Our Ref: N0241372-CLTR-01A

Project: Class 2 Mixed-use Project

Address: 37 Archer Street
Chatswood NSW 2067

Appendix A – 37 Archer Street Comments Register

OSD PLAN LAYOUT
SCALE 1 : 100

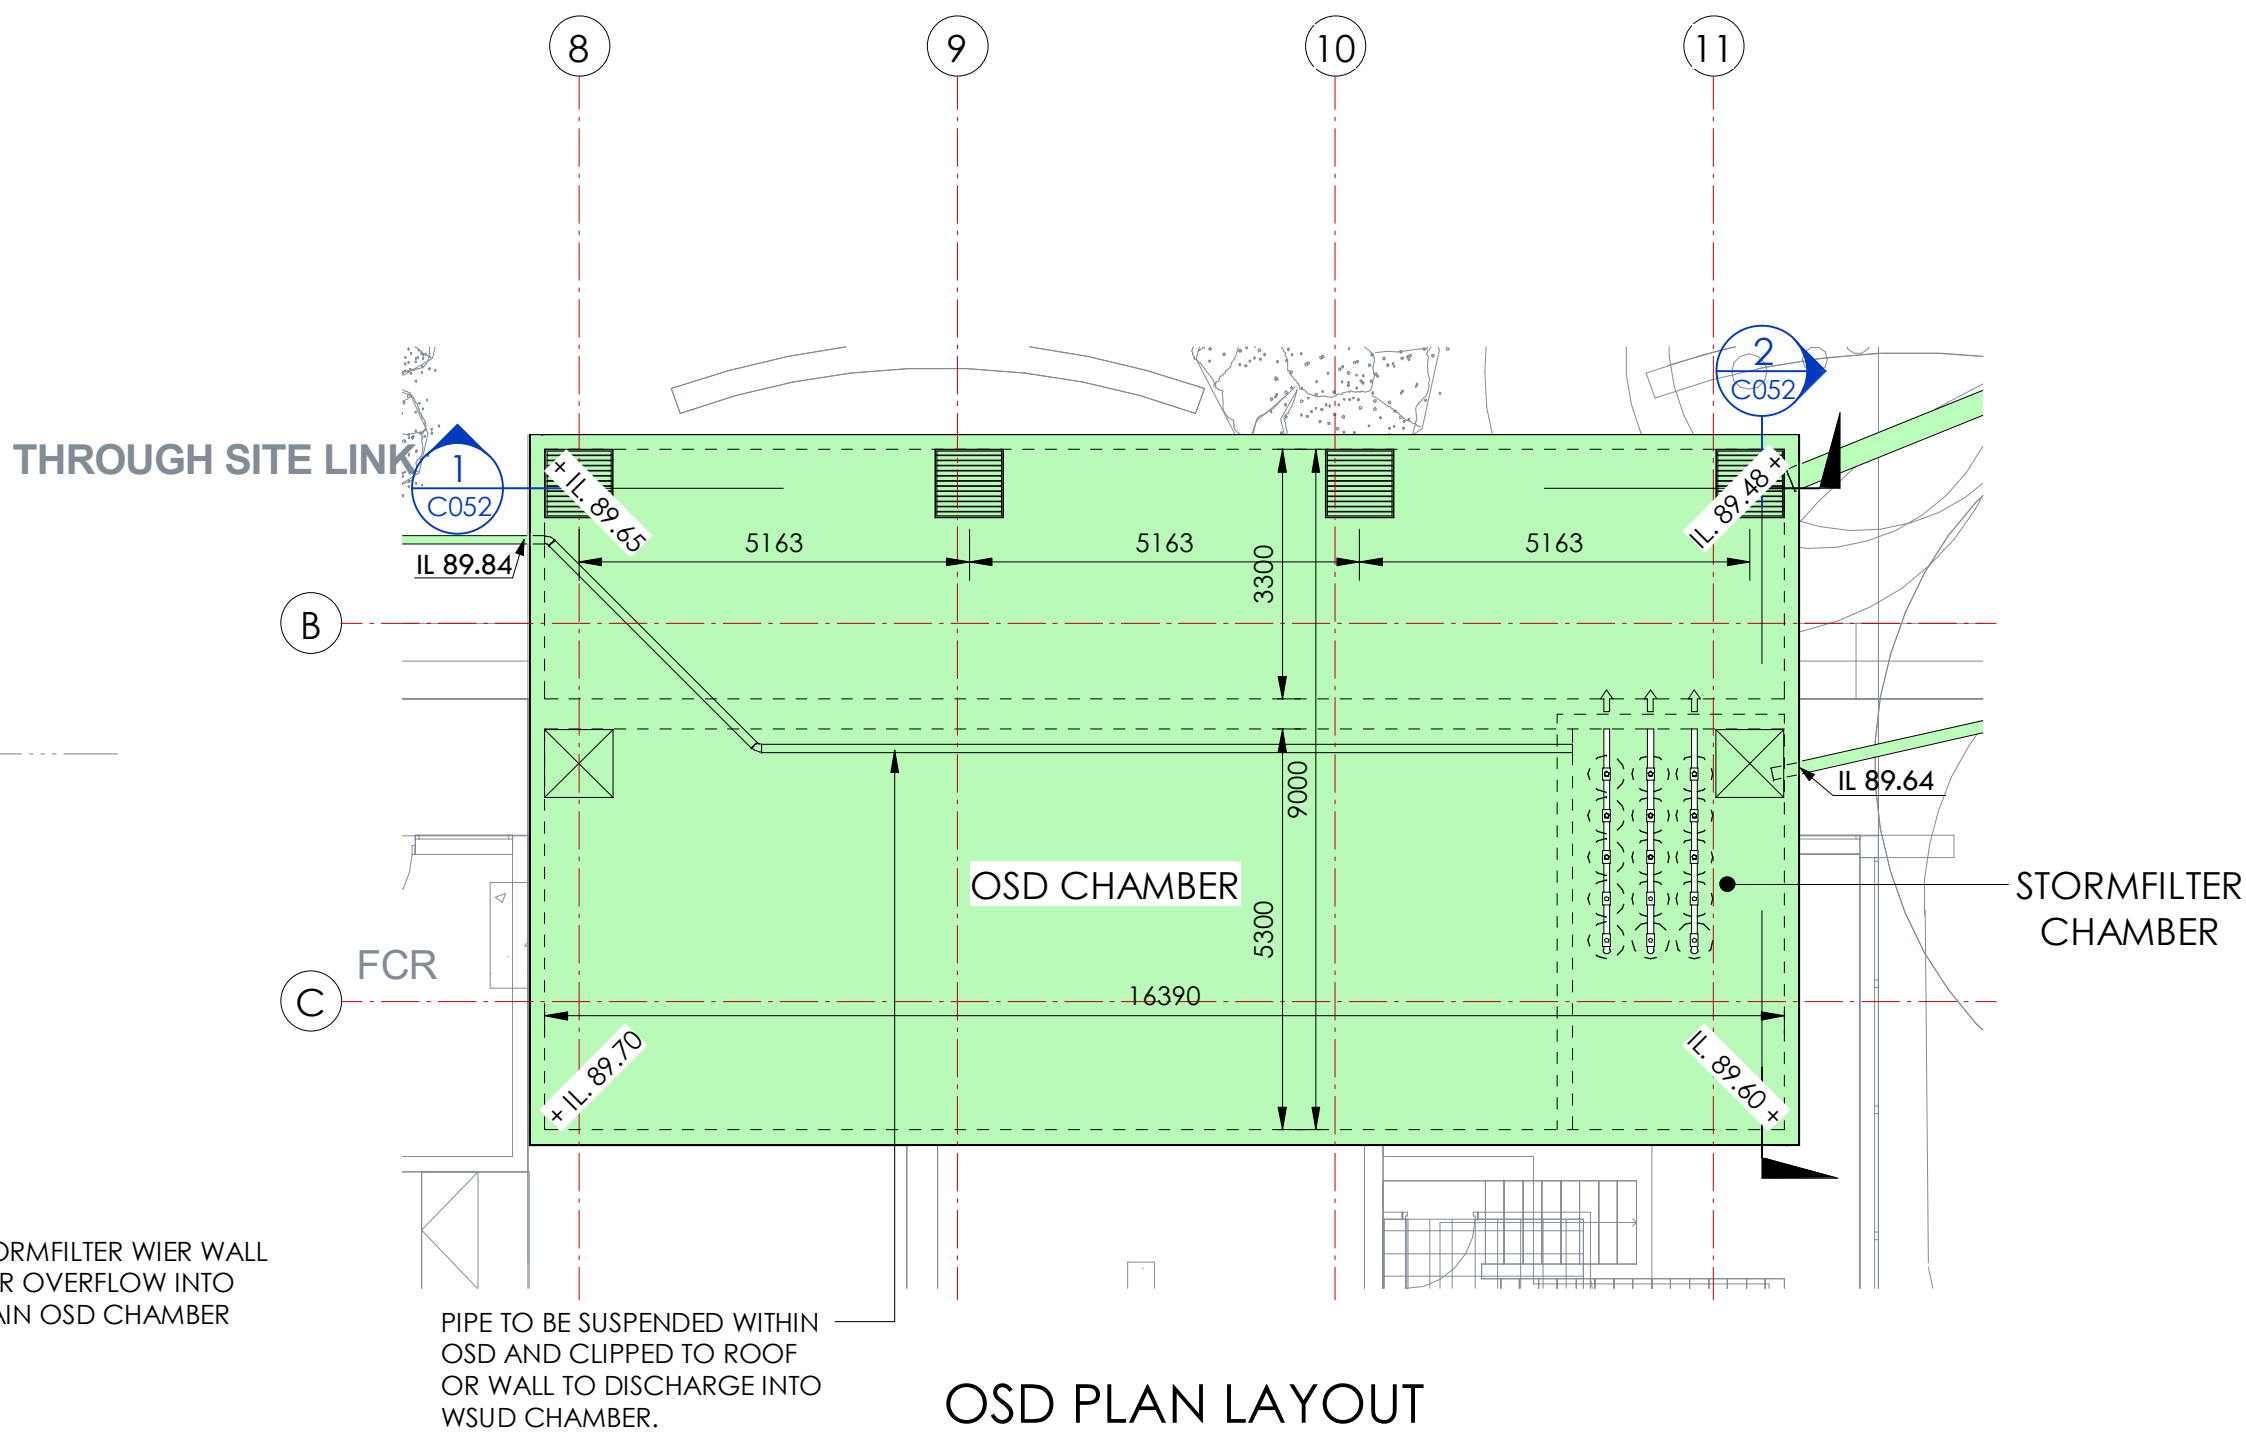
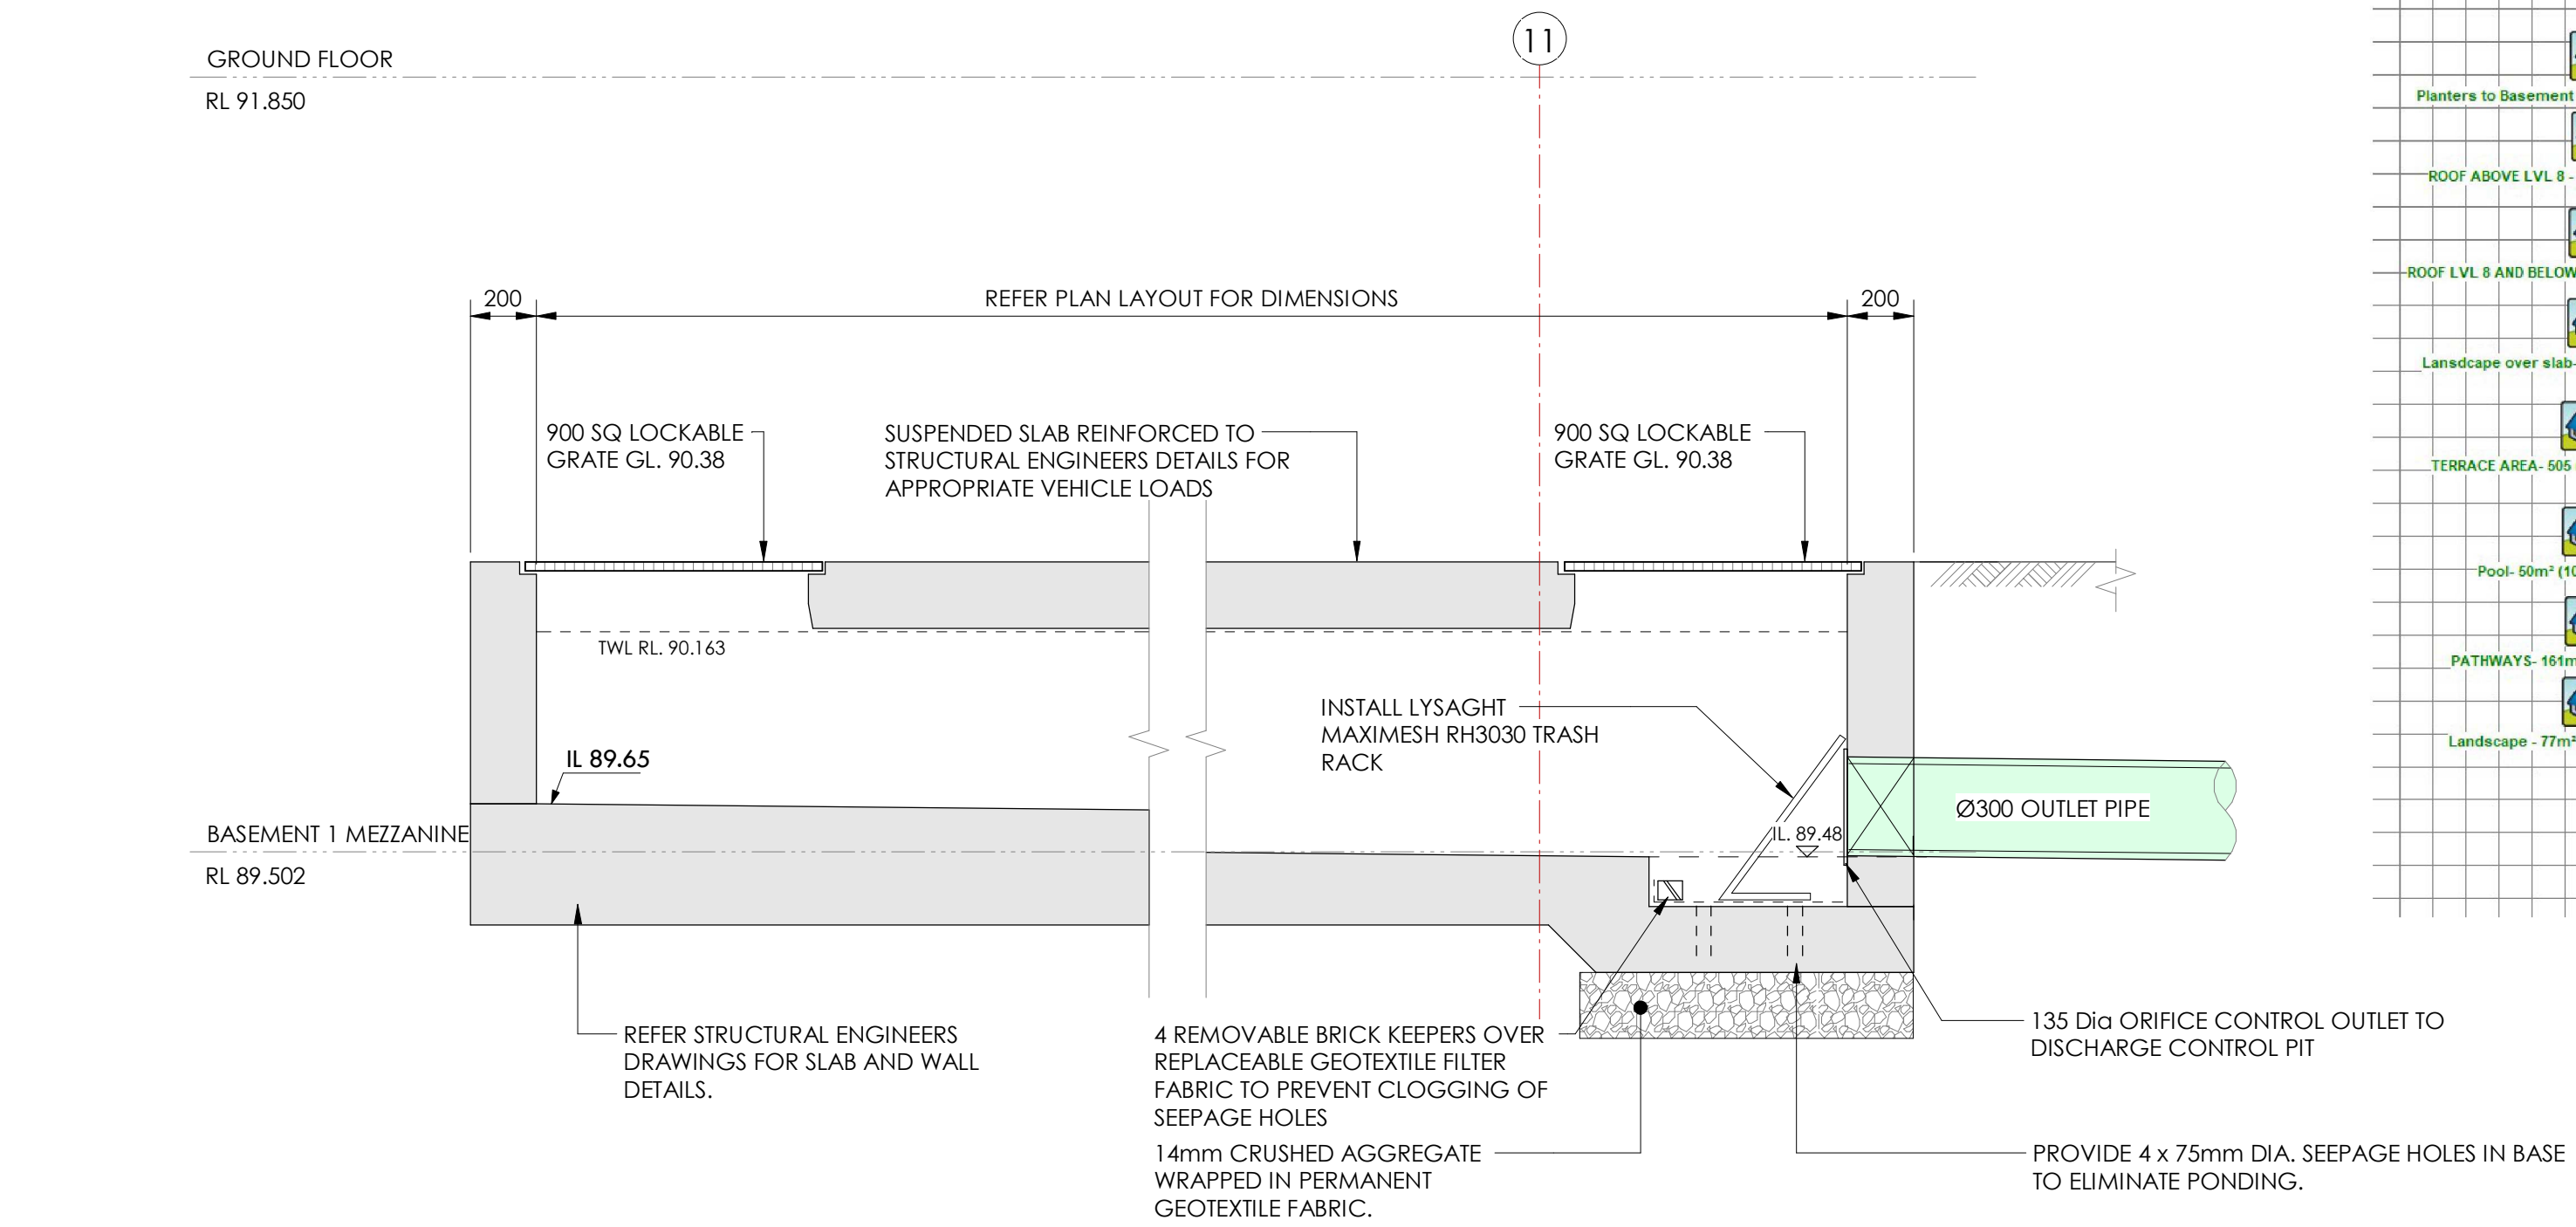
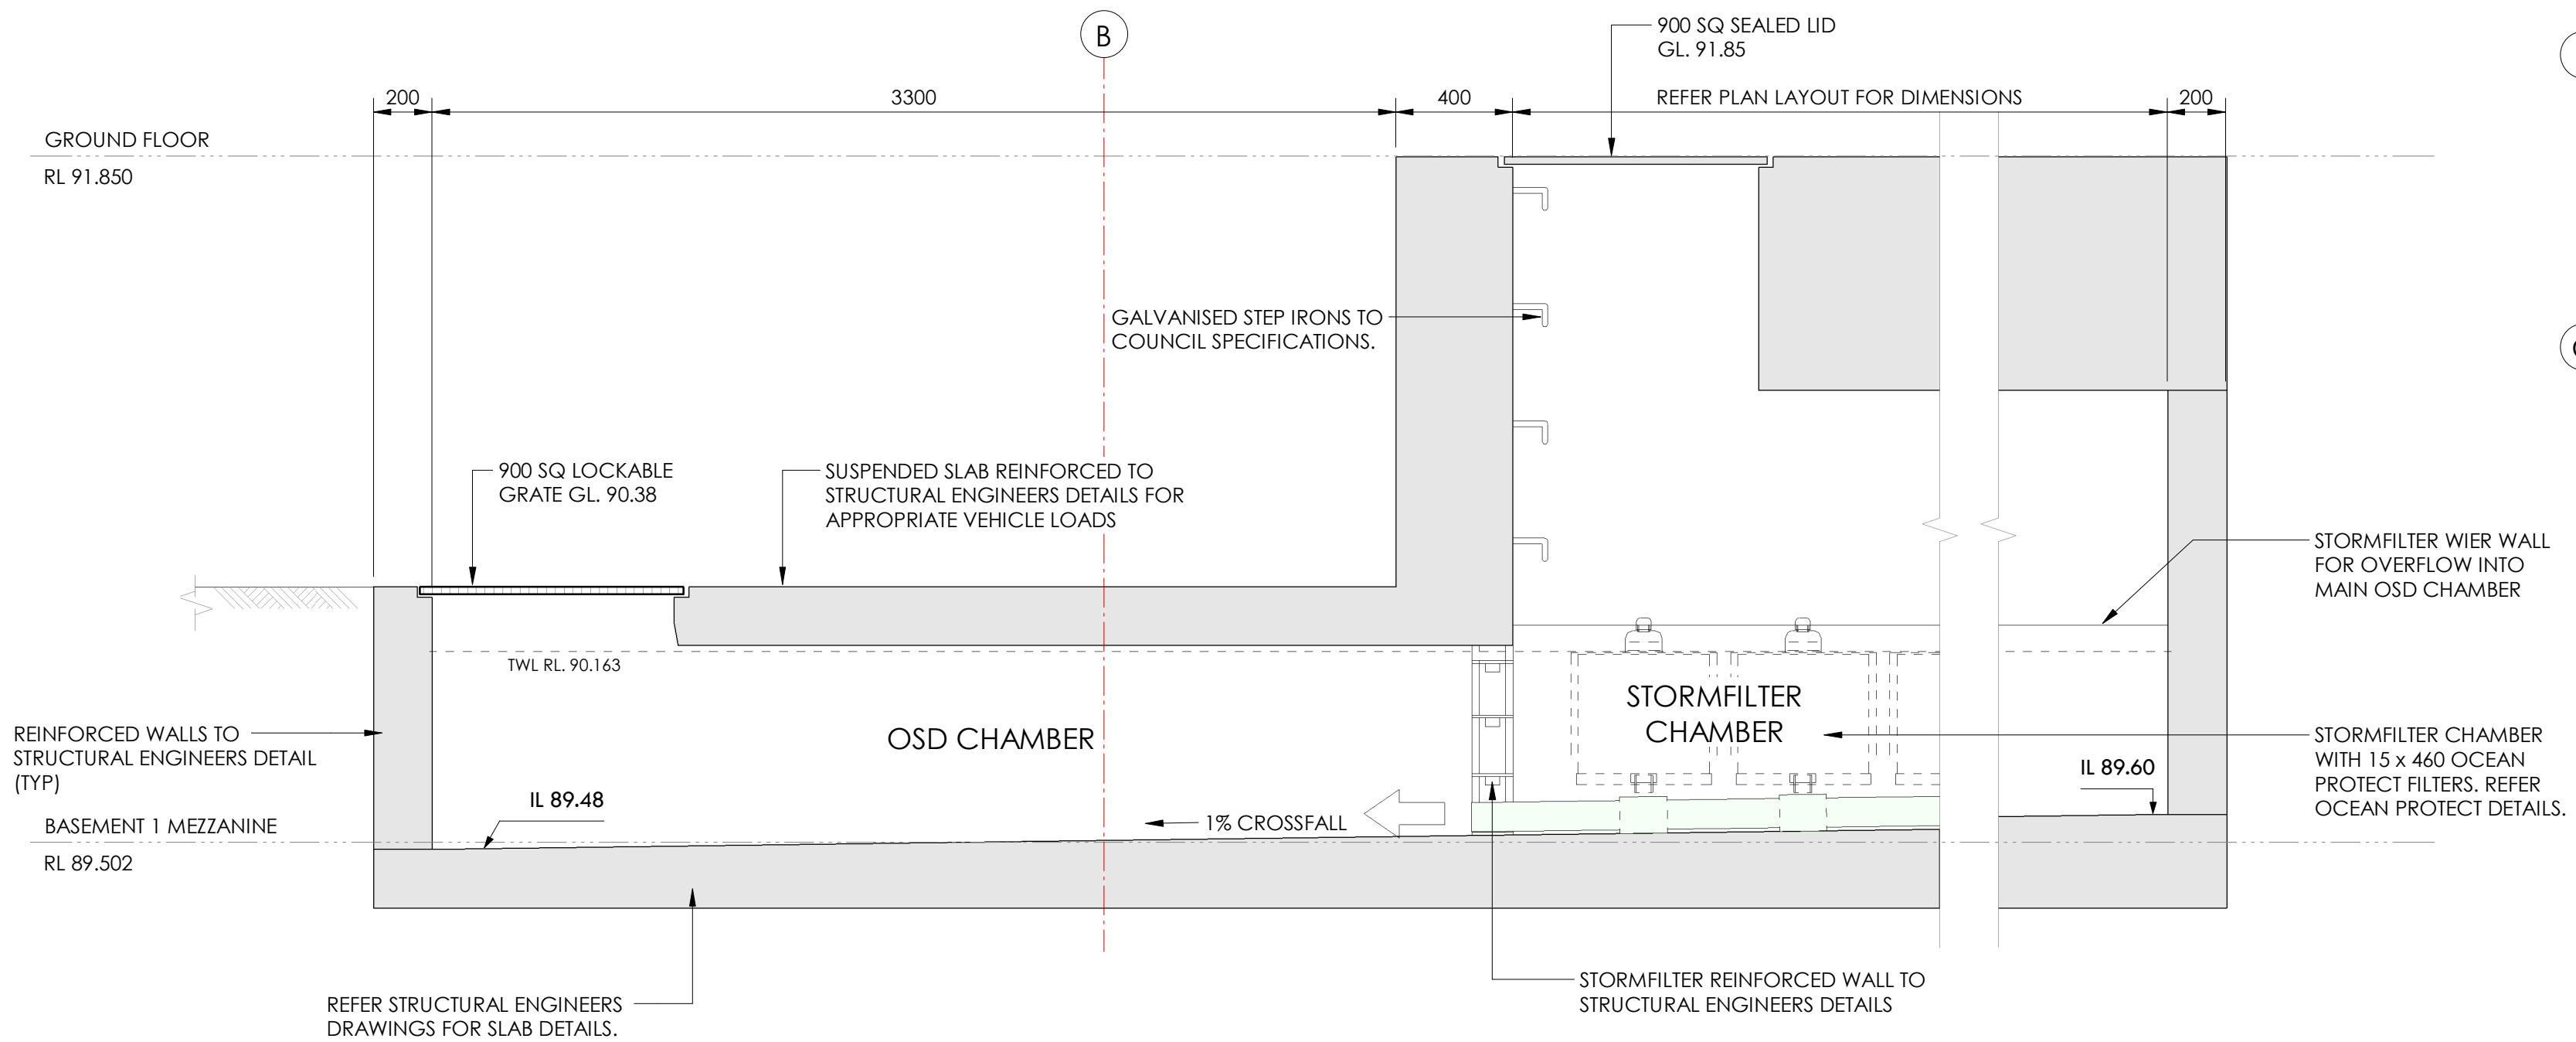
5	Section d) Stormwater Management of	Willoughby City Council	Access points to the OSD tank are generally location on one site only. To allow for cross-ventilation, safe	Access grates are located in the northern corners of the OSD tank, as well as over the outlet.	Drawing N0241372 C054 and C200.

Attachment 1 – Council Submission		<p>access to the tank and to minimise the need to enter the tank, access points should be located at all corners of the tank, and as a minimum over the outlet and the diagonally opposite corner. To ensure that access is available at all times, particularly for emergency maintenance, all access points to the tank need to be located in common areas and not in tenancies. The plans are not clear that this is achieved. The architectural plans should be amended to show the location of the OSD tank and all access points to the tank.</p>	<p>Access grates cannot be placed in the south-east and south-west corners of the OSD tank as these points are located within retail tenancies.</p> <p>All proposed access points to the OSD are in common areas and not in tenancies.</p> <p>Civil plans show updated OSD access points for coordination with architects.</p>	
6	Section d) Stormwater Management of Attachment 1 – Council Submission	Willoughby City Council	<p>As the tank is not located in a position where flows in excess of the capacity of the pipe network can drain to the OSD tank, the internal pipe network needs to be designed to cater for the flow from the 1%AEP event.</p>	<p>Internal pipe network has been designed and sized for flow from the 1% AEP storm event.</p>	Drawing N0241372 C200.
